THE  STAR

MODIFICATION 13 PLANNING SUBMISSION

AIR QUALITY AND MECHANICAL
SERVICES REPORT –
RESPONSE TO SUBMISSIONS

TO: Whom it may concern
FROM: Giancarlo Oradini
SUBJECT: **Air Quality and Mechanical Services Reports for Modifications 13 Planning Submission – Response to Submissions**
OUR REF: 181105-The Star-Mod 13-Mech-Air Quality_Response to Submissions rev04.docx
DATE: **5 November 2018**

Scale	Date Printed
1:500 @A1	11/6/2018 2:16:57 PM
Project Number	Drawing Number
AUSYD160165	MOD13-AS1006
Issue	G

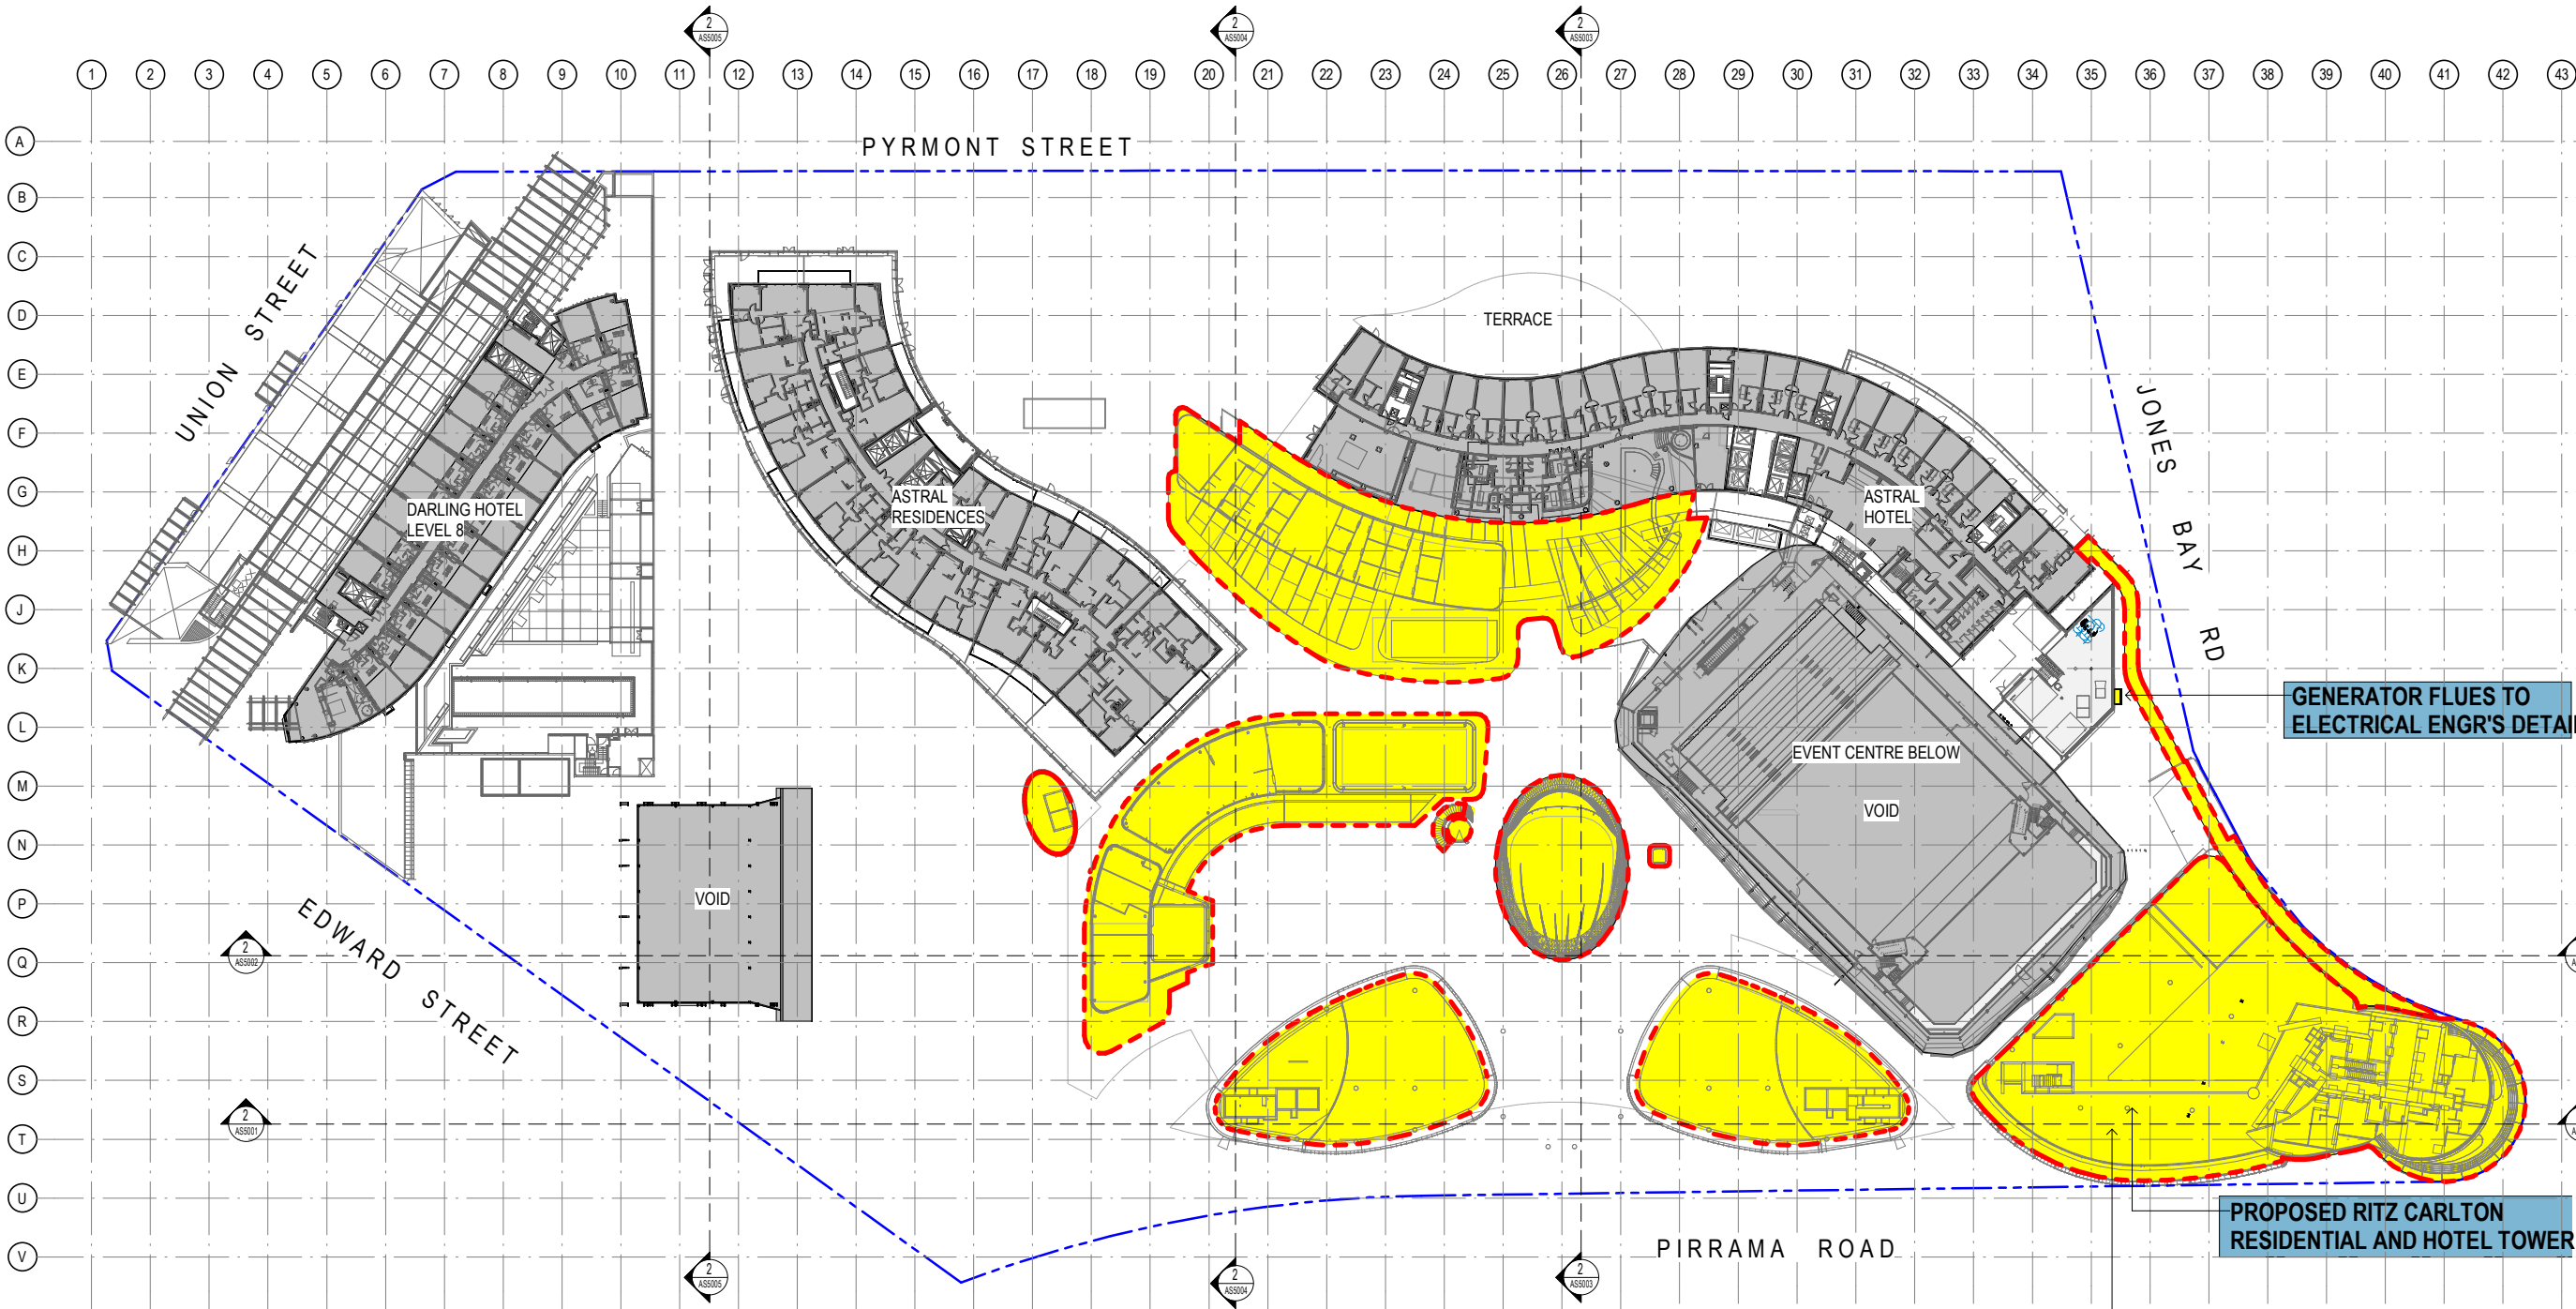
Exacerbated odour impacts on our client's enjoyment of their residences will occur due to the intensification of uses in The Star development and increases in building proximity

For clarity, we have identified the kitchen exhaust discharges on the architectural plans (extracts below):

- For new Darling Union and Edward Streets F&B,
 - Refer to DWP drawing, MOD13-AS1003 and MOD13-AS4002.
- For existing Level 01 MGF F&B, Level 05 Bistro, Residential Entrance Level Restaurant (Level 00) and New Restaurant Street Level 00
 - Refer to FJMT drawing, AF1006
 - Refer to DWP drawing, MOD13-AS4001
- For Level 5 Sky Terrace Restaurants, Level 7 F&B, Existing Level 00 F&B and Level 02 Nightclub
 - Refer to FJMT drawing, AF1008
 - Refer to DWP drawing, MOD13-AS4001
- For existing MUEF kitchen exhaust and relocated diesel generator flues,
 - Refer to DWP drawing, MOD13-AS1009 and MOD13-AS4002
